**SSD-52861709 – Multi-Level Warehouse development at 92-116 Gow Street, Padstow
Submission to the Environmental Impact Statement – Canterbury Bankstown City
Council**

Attachment A – Council’s comments for State Significant Development Application SSD-52861709

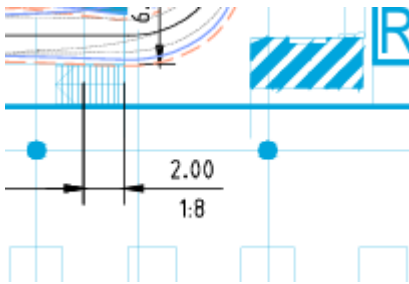
- 1) Vehicle Footpath Crossing:
 - a. Existing Vehicle Footpath Crossing (VFC) and new VFC dimensions. Shared VFC between heavy rigid vehicles and cars is not supported and separate VFC must be provided
 - b. The eastern most VFC will need to be widened to minimise impact on the kerb and gutter and loss of on-street parking
 - c. There are various entries that are not wide enough to accommodate a HRV. Please refer to Attachment B.
 - d. The VFC for the western most exist driveway needs to be clearly shown on the plans to allow full assessment on the turning paths
 - e. The location of the pedestrian access between two heavy vehicular access is not safe and must be relocated towards the western boundary

2) Internal Manoeuvrability

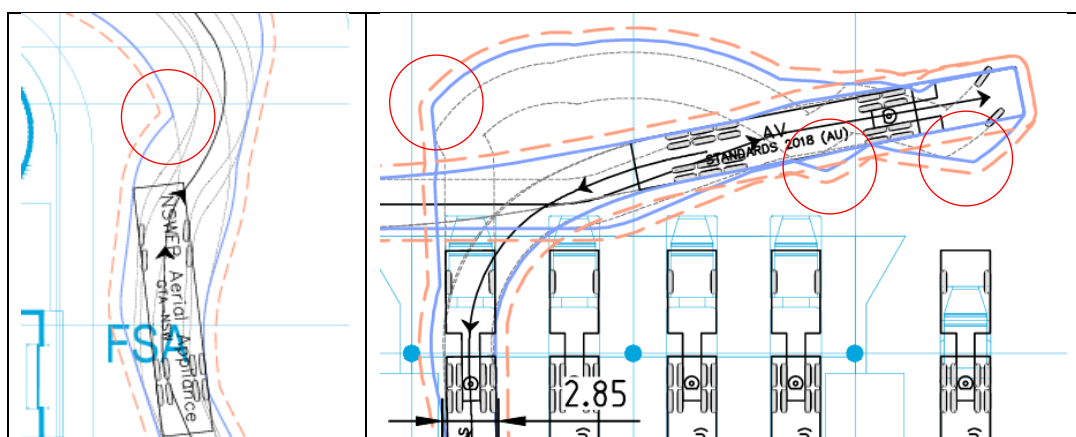
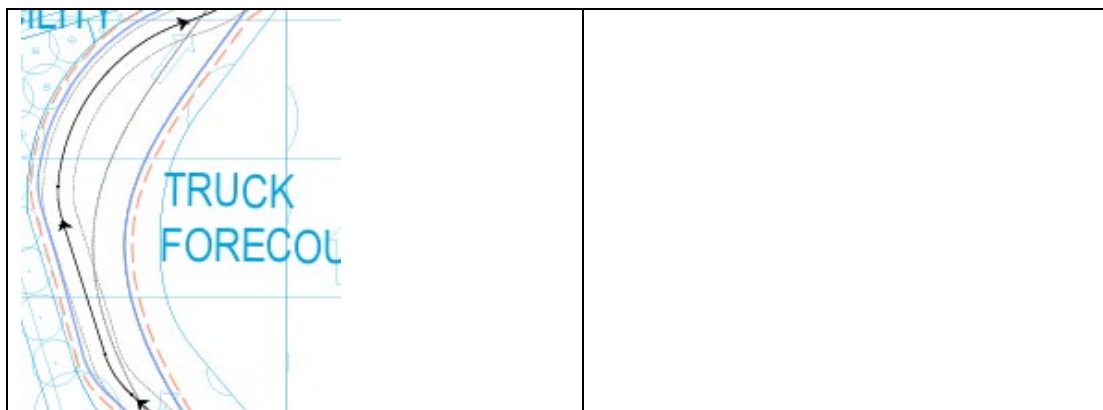
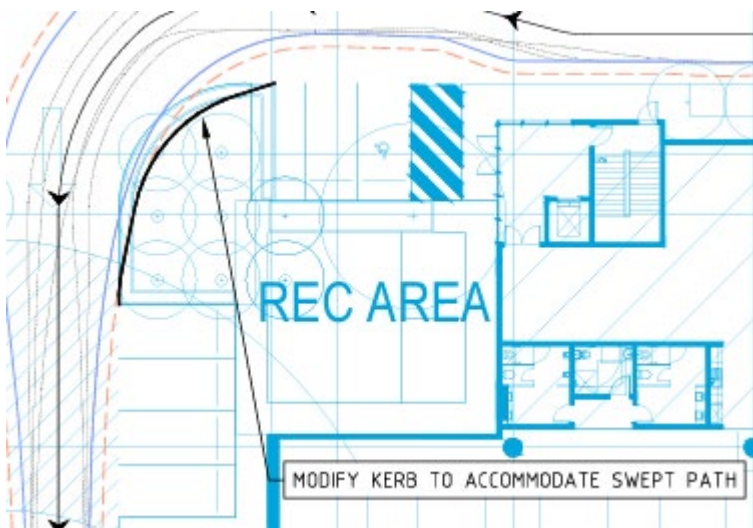
- a. There are a number of impractical turning paths within the site. Please refer to Attachment B.
- b. Turning paths for B85 vehicles are to be shown on a separate drawing for clear assessment. The below drawing is not acceptable.

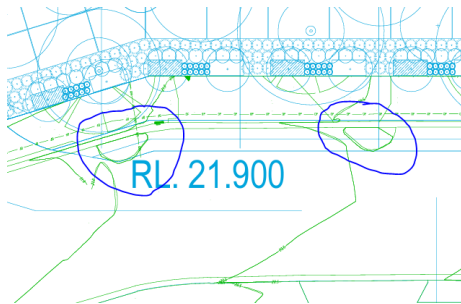
- a. The applicant is to fund the installation of a minimum 1.5m wide footpath along the frontage of the site in Gow Street.
- b. The applicant is to fund any relocation of power poles on the street verge and removal of traffic islands no longer required. Please refer to Attachment B.
